An Bord Pleanála
Strategic Housing Unit
64 Marlborough Street
Dublin 1
D01 V902

Date: 23 May 2022
Our ref: 3237/22/5
Your ref: ABP - 313361

Re: SHD planning application for the construction of a total of 415 No. residential units (252 No. houses, 135 No. apartments, and 28 No. duplex units); with 1 No. childcare facility and ancillary residential amenity facilities, a proposed Strategic Housing Development, on lands at Back Road & Kinsealy Lane, Kinsealy, Broomfield, Malahide, Co. Dublin.

Boundary Treatment | Northern Section | 1:1000

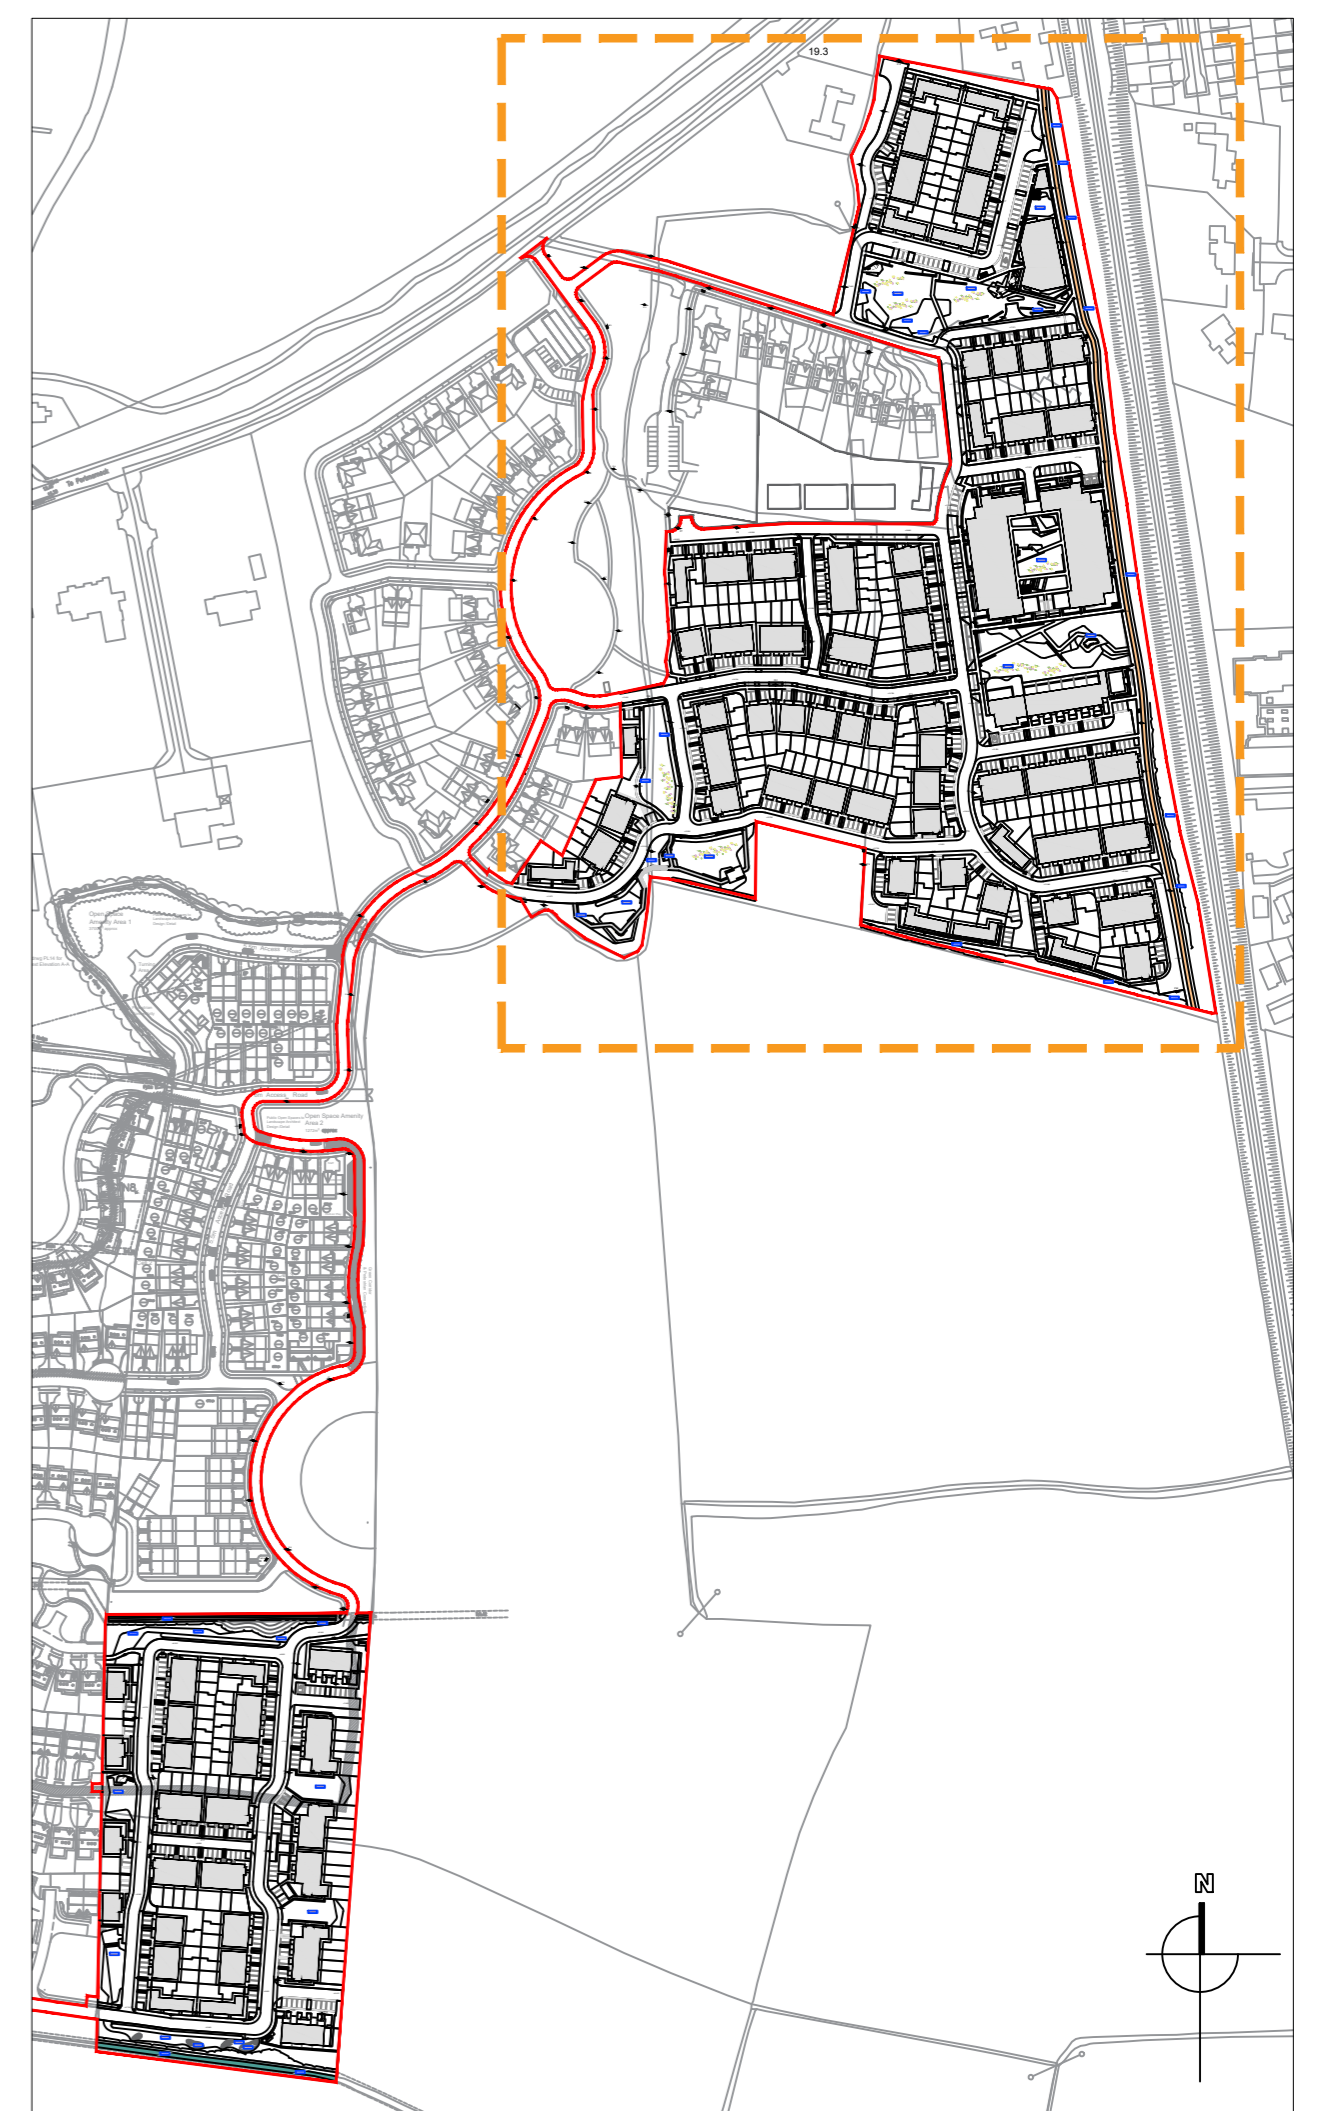
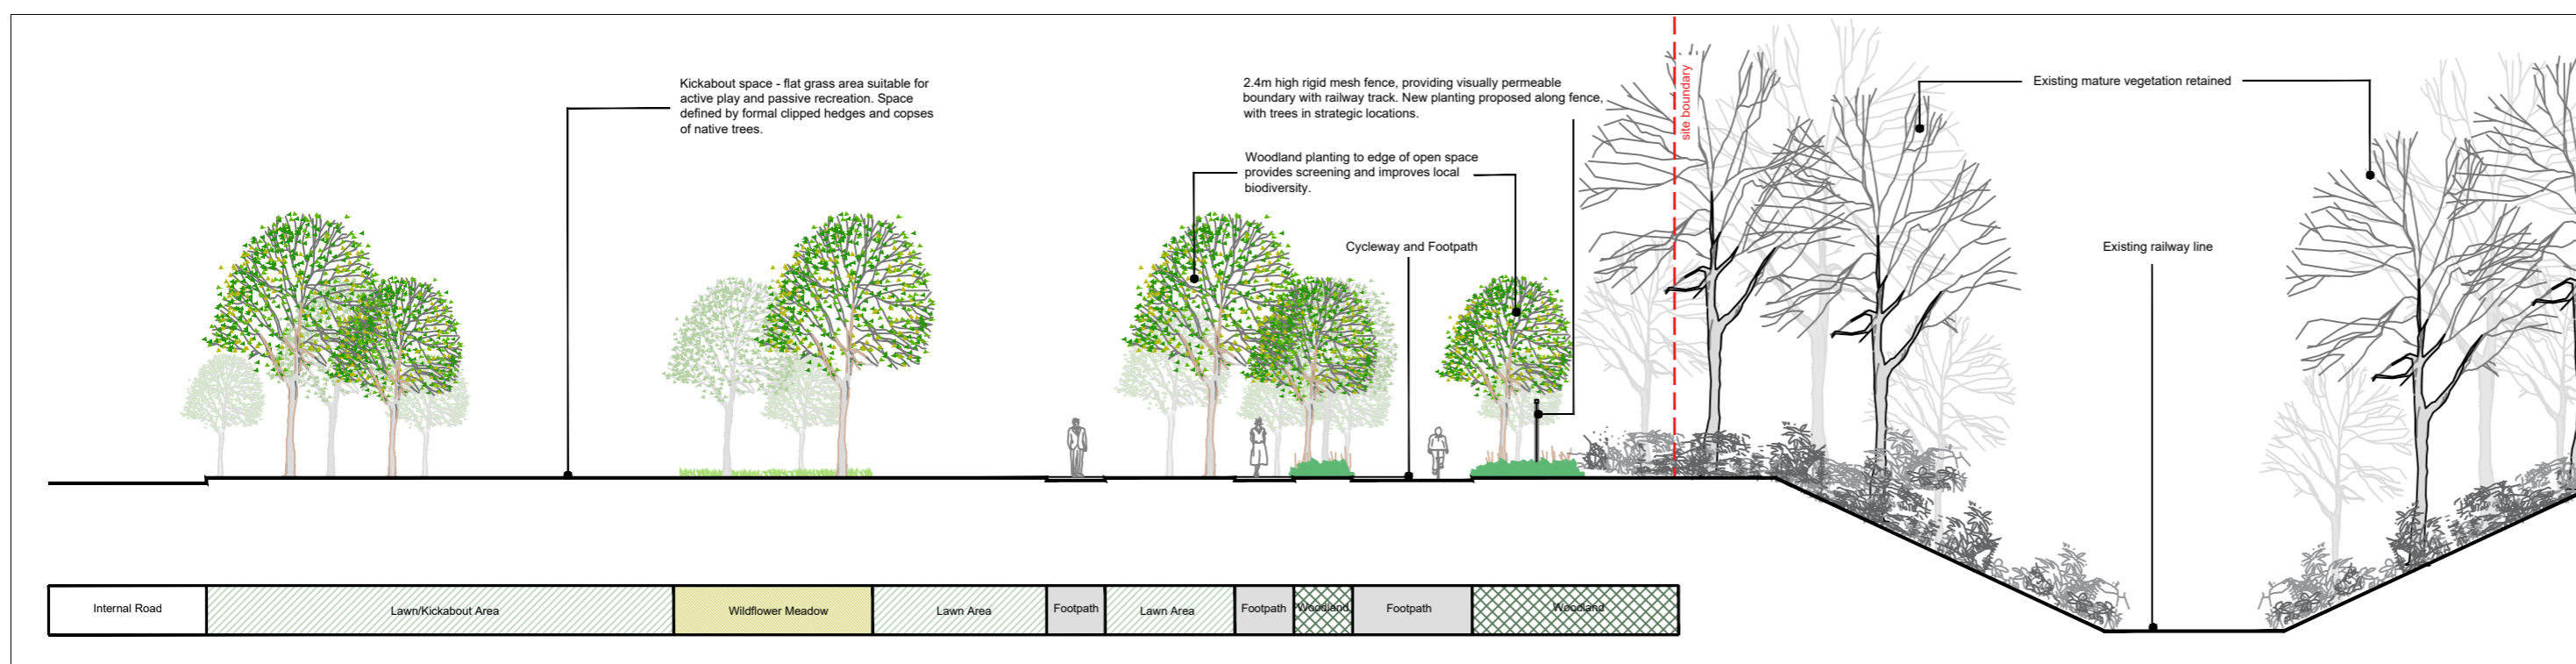
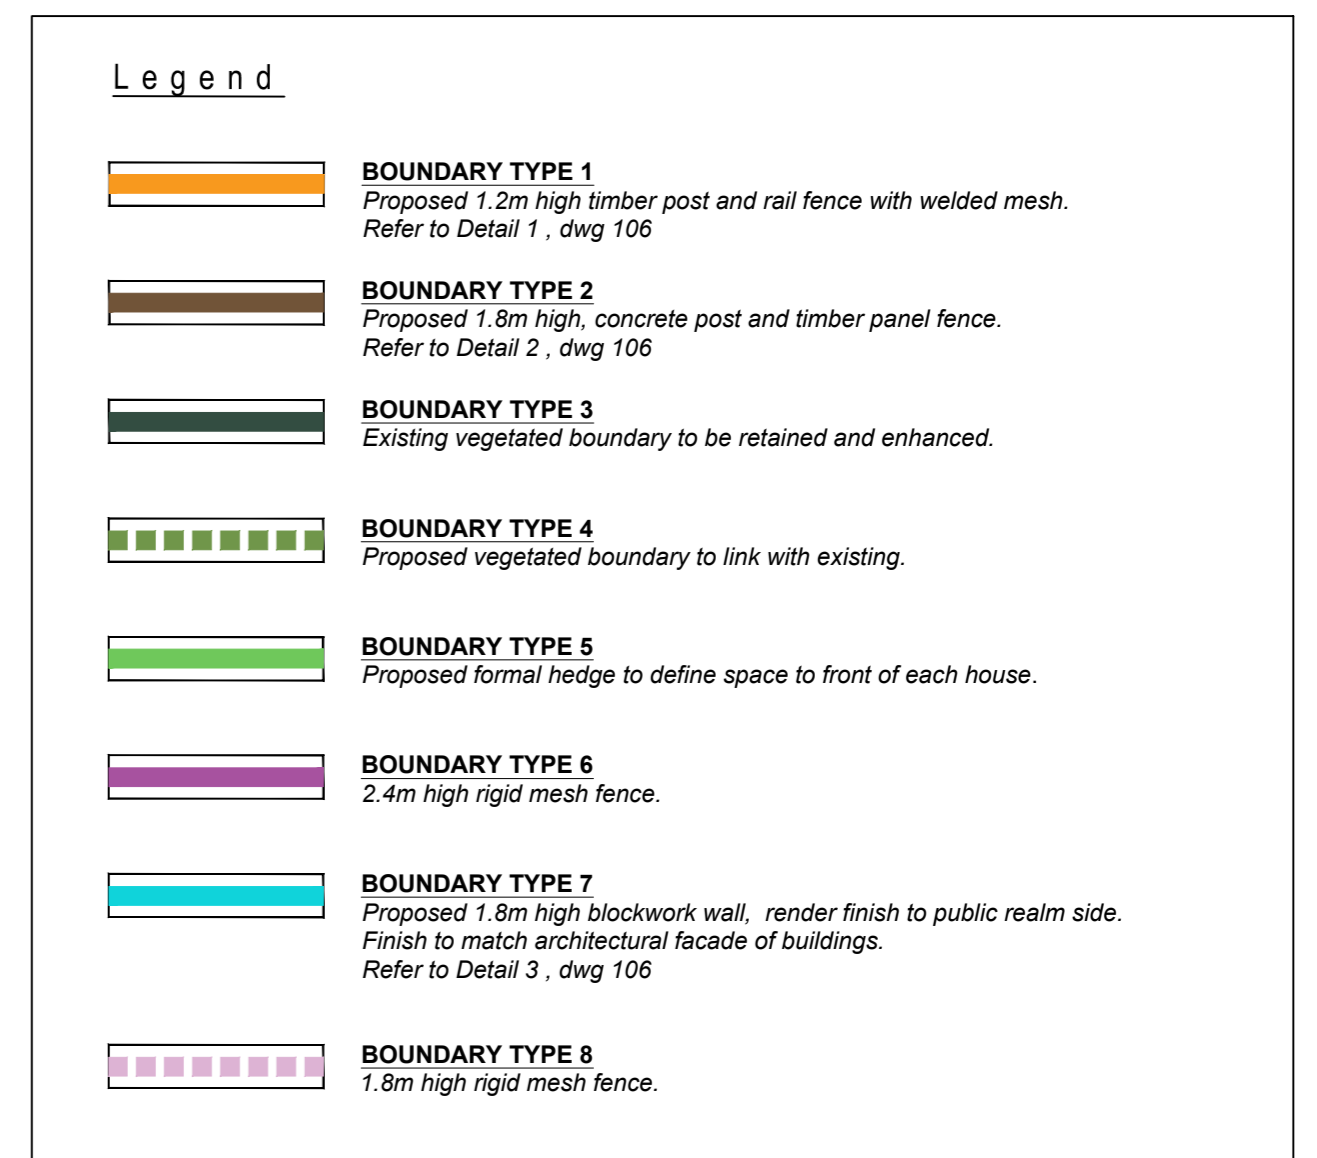
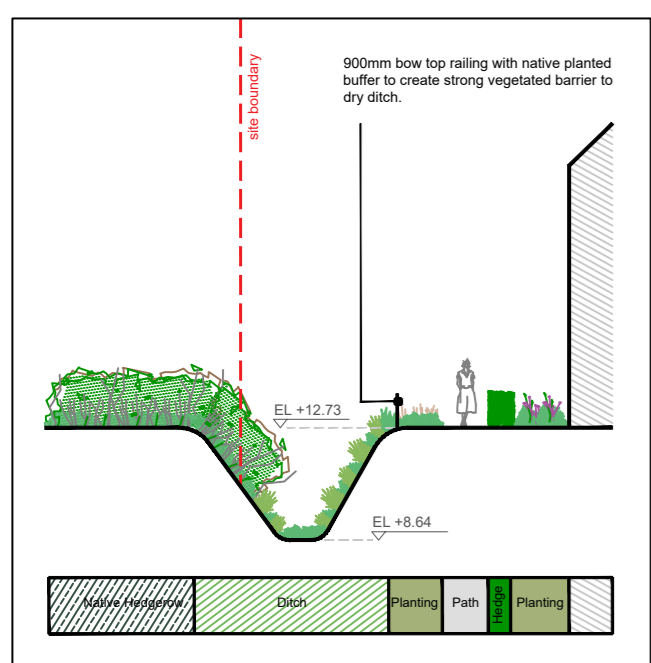
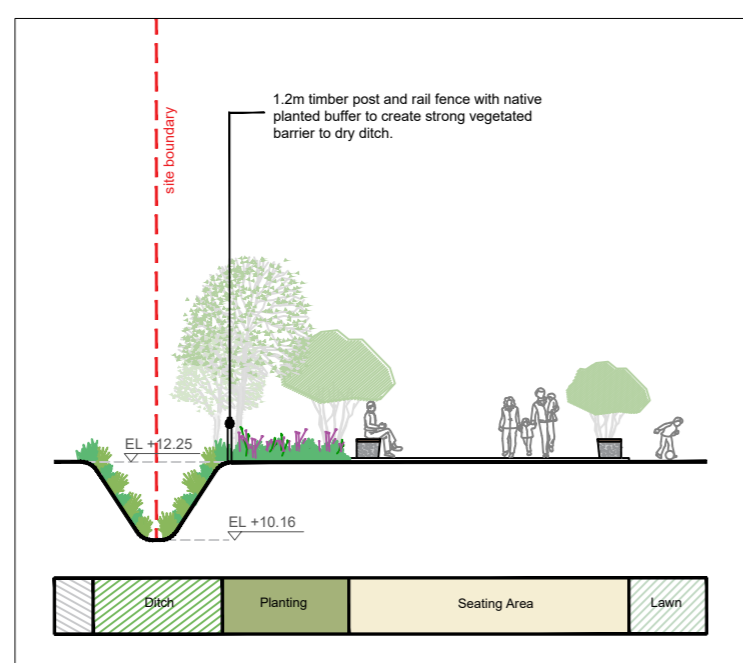
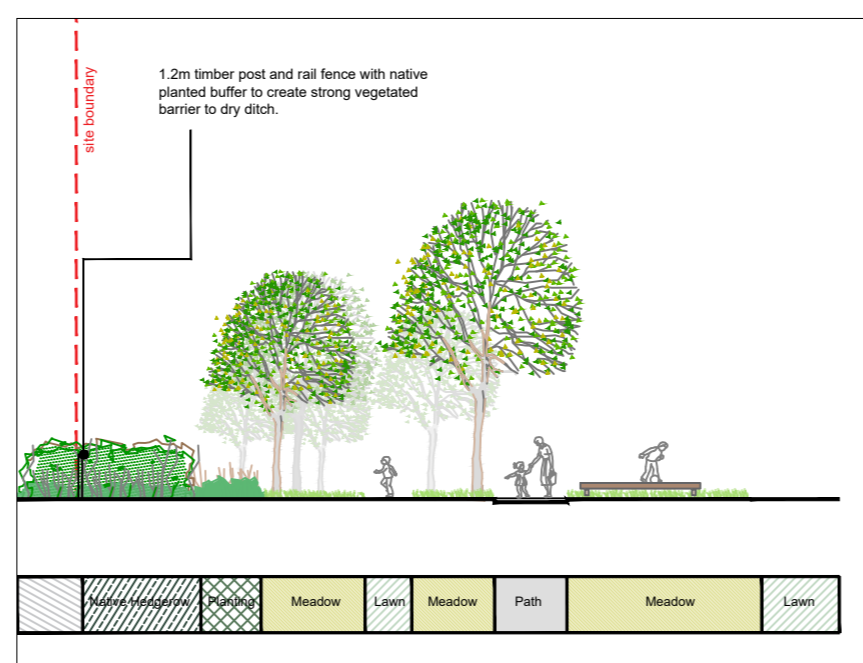
- 3) The site boundary shown on the plan drawings assumes that the property boundary to railway lands corresponds with OSi mapping. This approach is unreliable and does not take account of the historical drainage channels running parallel to the railway at the crest of the cutting which fall within the original land take for the railway corridor. It is therefore probable that the proposed development encroaches onto CIÉ/Iarnród Éireann lands. It is noted that the drawings provided by the applicant under the heading of Architectural Drawings do not specify a dimension between any new boundary wall and the track, or alternatively GPS coordinates for the line

of the wall that would allow for comparison with the Railway's records for the boundary line along this section. The Applicant should engage with Iarnród Éireann and provide detailed cross sections with a view to agreeing the line of the proposed boundary treatment.

- 8) In keeping with a residential development of this scale and density a 2.4m minimum high appropriately designed, solid block/concrete boundary wall treatment, should be erected by the applicant on the applicants' side of the boundary to the Railway. The maintenance of this boundary treatment rests with the Applicant and Successor-in-Title. It is noted that the planning documentation refers to provision of a new boundary welded mesh fence at the track interface, this however is not in keeping with the access and security issues associated with a development of this scale and type. As mentioned previously, the exact location and details of the boundary treatment are to be identified on site in co-operation with this office.
